STATE OF NORTH CAROLINA  
DEPARTMENT OF TRANSPORTATION

February 12, 2019

Subject: **Resubmittal of the Application for CAMA Major Development Permit** for the Proposed Improvements to US 17 Business / NC 37 (North Church Street) from South of the Perquimans River Bridge NC 37; including the replacement of Bridge No. 8 in Perquimans County, North Carolina; TIP No. R-4467; Federal Aid Project BRNHS-0017(85); Debit \$475 from WBS No. 35748.3.2

Figure A-1

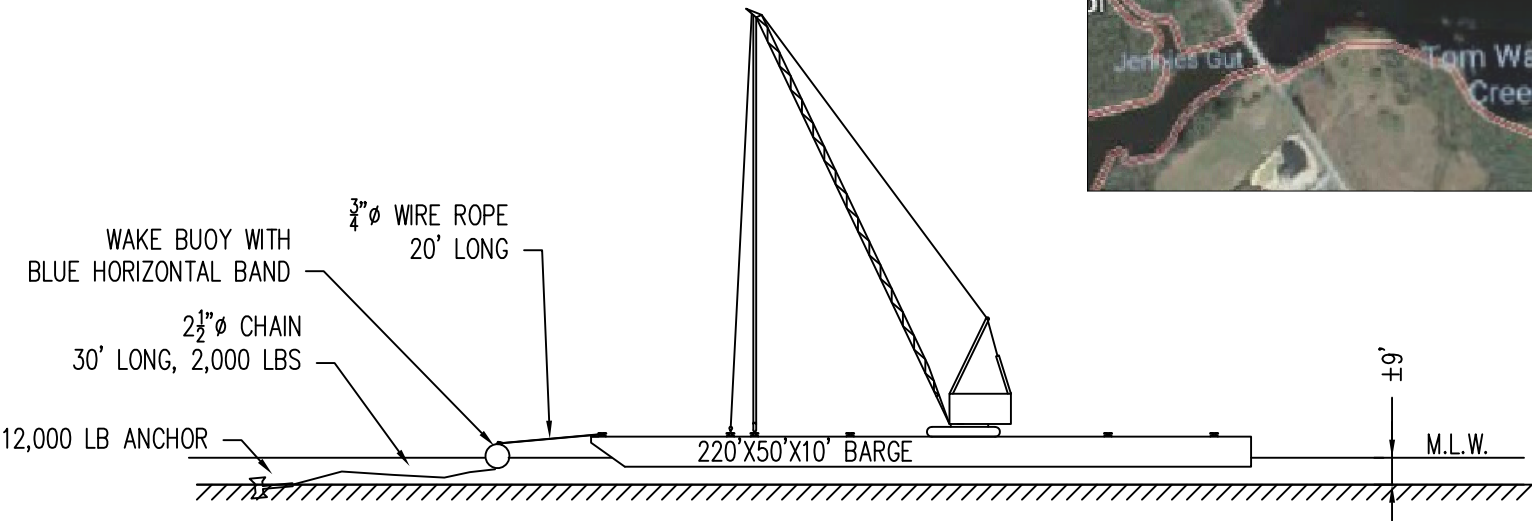
The purpose of the temporary boat landing is to provide a gangway to access the barges and small boats needed to relay equipment. An 18-inch pile will be used to hold the gangway in place. The barges will be moored in temporary mooring locations shown in Figure A-1 in Appendix A. A schematic of the mooring locations is also included in Figure A-1. The location of the gangway is shown on Permit Drawing 2 and 3 of 17. A picture of an example gangway (Figure A-2) used on a recent project is attached in Appendix A.
